WEST SUSSEX COUNTY COUNCIL CONSULTATION

TO:	Arun District Council FAO: Kaur Singh
FROM:	WSCC - Highways Authority
DATE:	14 May 2021
LOCATION:	Land adjacent to Woods Way House, 3 Torton Hill Road, Arundel, BN18 9HF
SUBJECT:	AB/48/21/PL Construction of 1 No. three bedroom dwelling & associated works. This site is in CIL Zone 2 & is CIL Liable as new dwelling.
DATE OF SITE VISIT:	N/A
RECOMMENDATION:	Advice
S106 CONTRIBUTION TOTAL:	N/A

Site/Block Plan

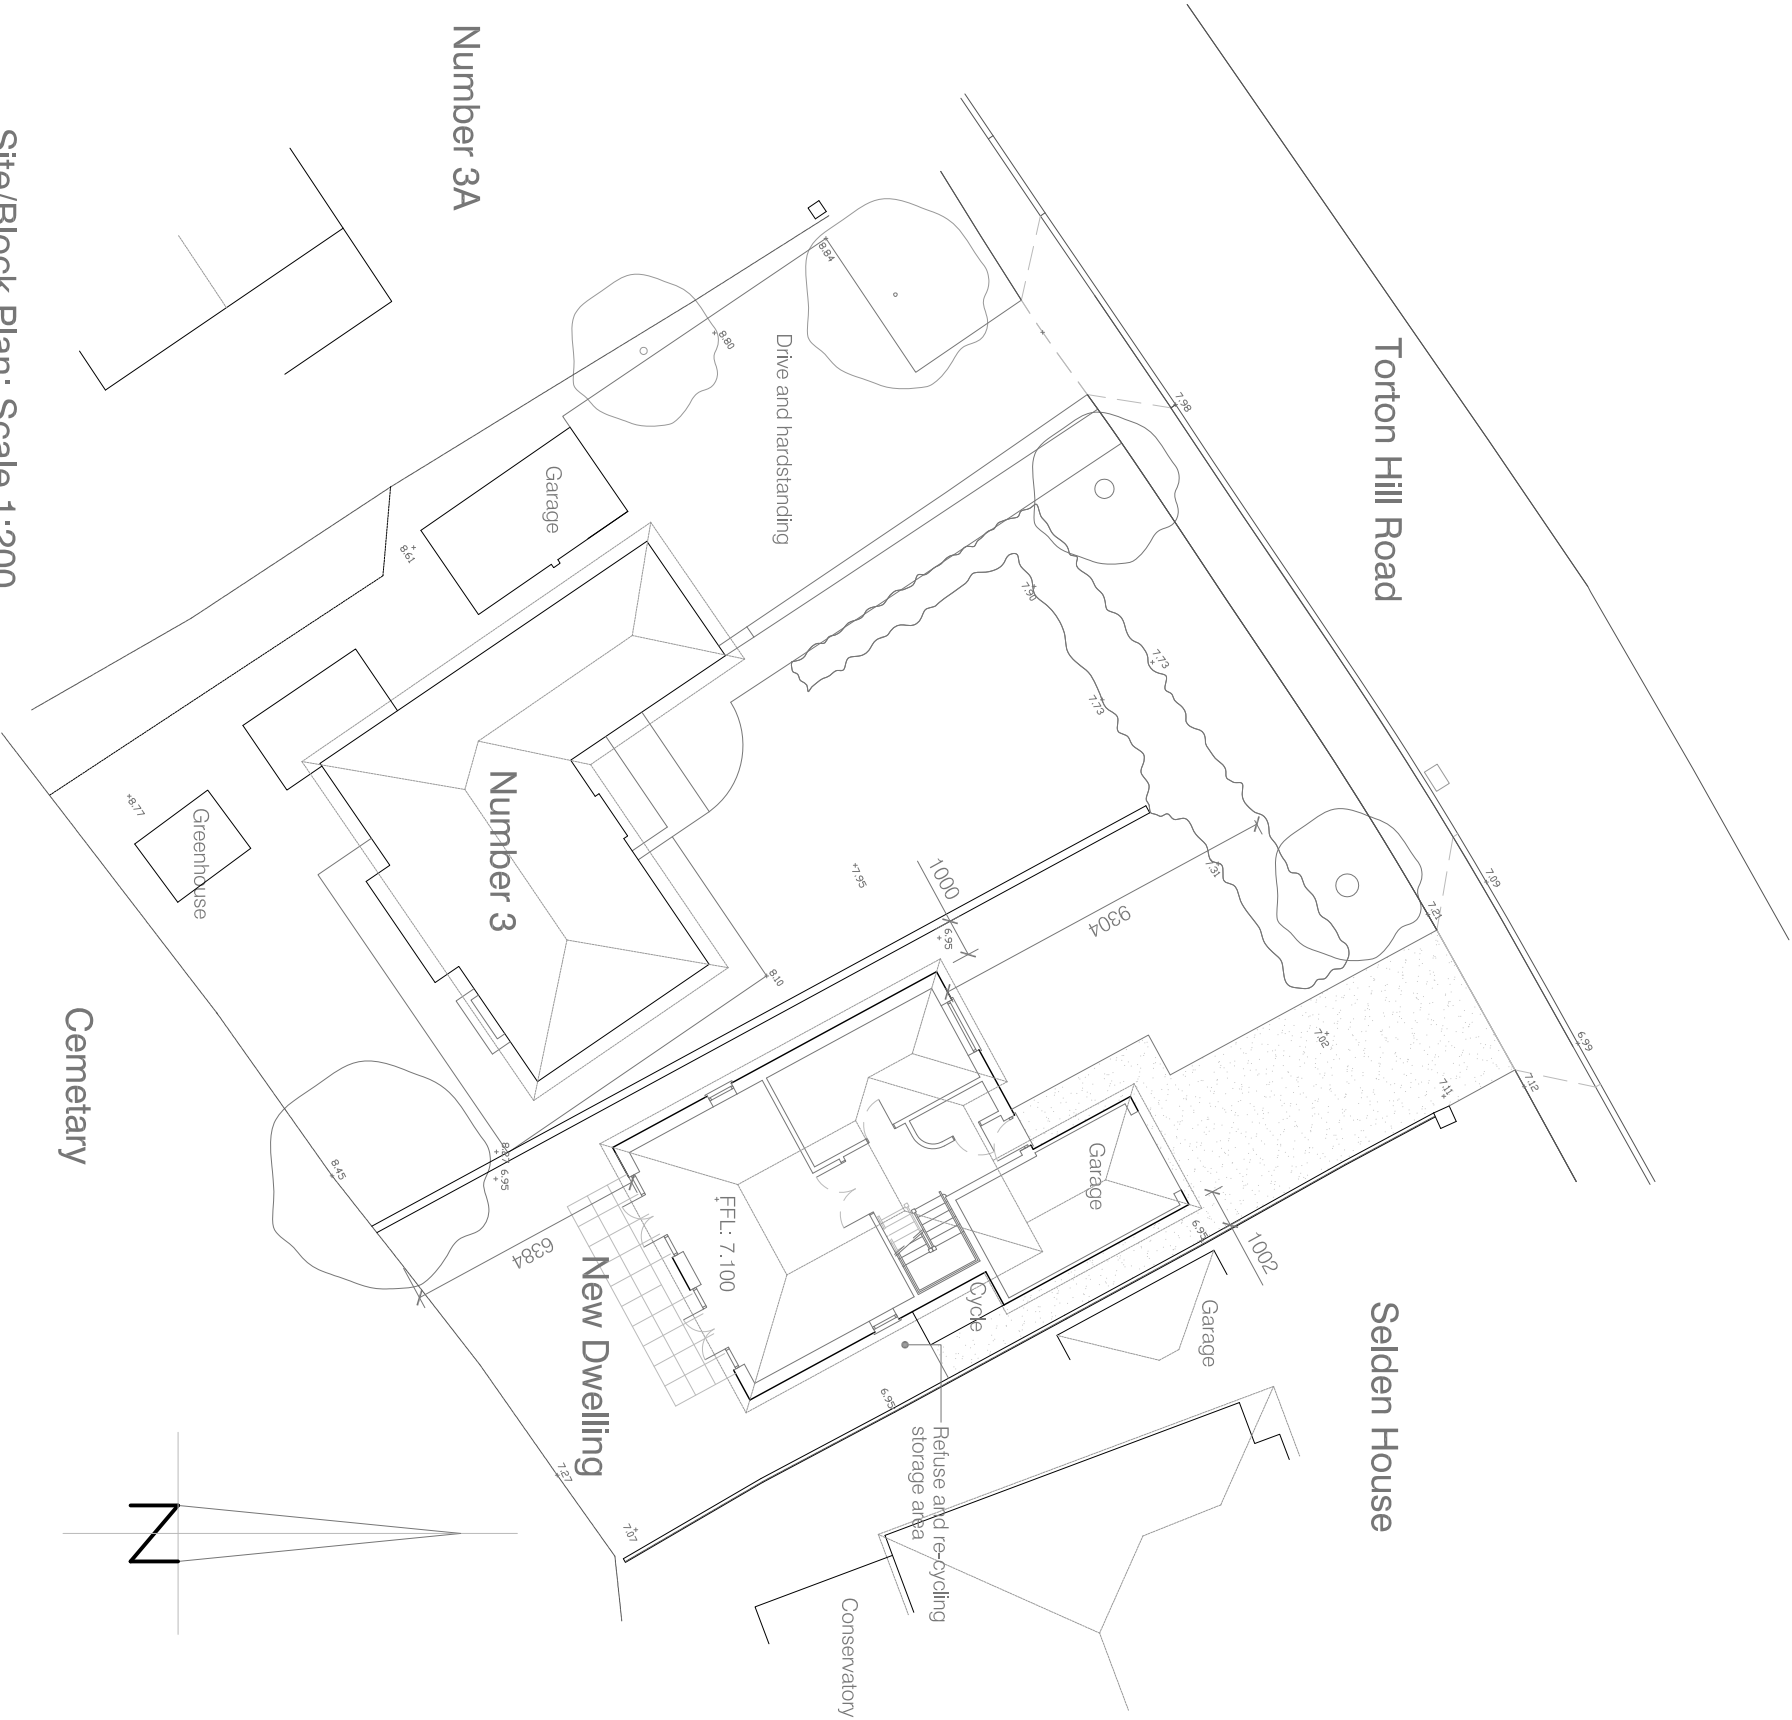
The applicant proposes a new vehicular access onto Torton Hill Lane. The proposed vehicle crossover (VCO) will be subject to a licence obtained through the local area office and constructed to a specification agreed with the local area engineer. From inspection of local mapping, vehicular visibility appears sufficient in both directions at the proposed point of access onto the maintained highway.

On-site turning does not appear achievable, so vehicles may have to exit the site in a reverse gear. However, this is not anticipated to result in a highway safety concern.

The applicant has demonstrated cycle storage to the rear of the plot, in accordance with Arun Parking Standards. The inclusion of secure and covered cycle parking helps promote the use of sustainable transport methods.

drawing
Ground and First Floor Plans,
Roof Plan and Typical Section
As Proposed

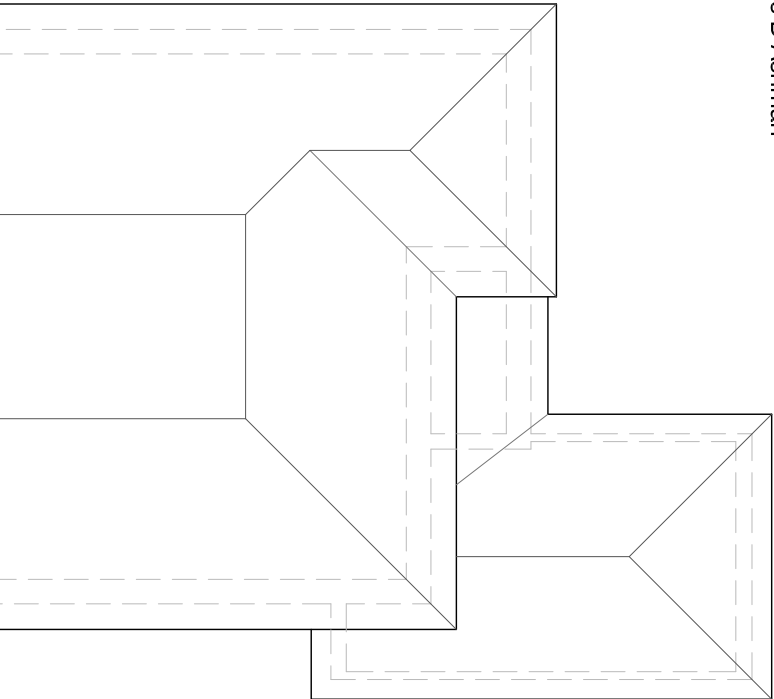
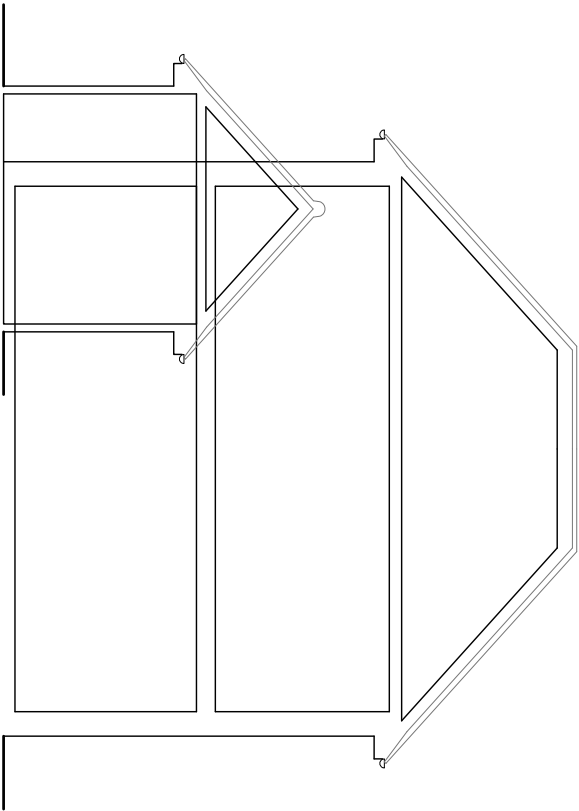
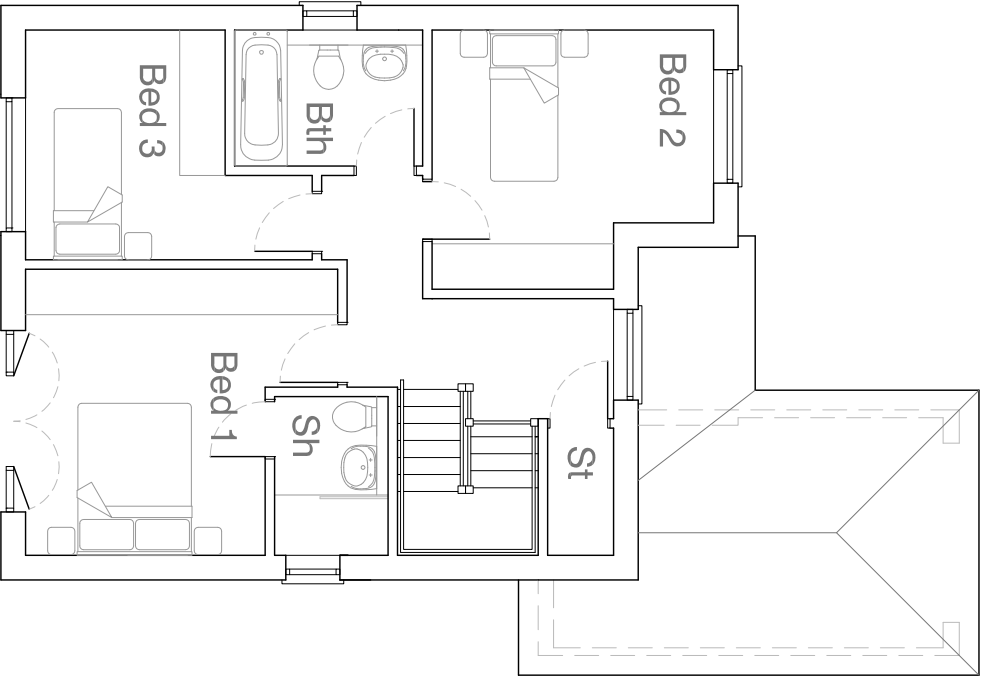
The applicant proposes two car parking spaces for this development, in the form of a single-car garage and driveway. The LHA notes that the proposed garage does not meet the minimum internal specifications for single-car garages of 3m x 6m as set out in Manual for Streets (MfS), and therefore cannot be considered for parking provision. The LHA advises the applicant to enlarge the garage to meet MfS specifications.

Under Arun Parking Standards, the LHA would expect a dwelling of this size in this location to provide at least two car parking spaces. If the applicant can enlarge the garage to MfS specifications, the LHA will be satisfied with the proposed parking provision.
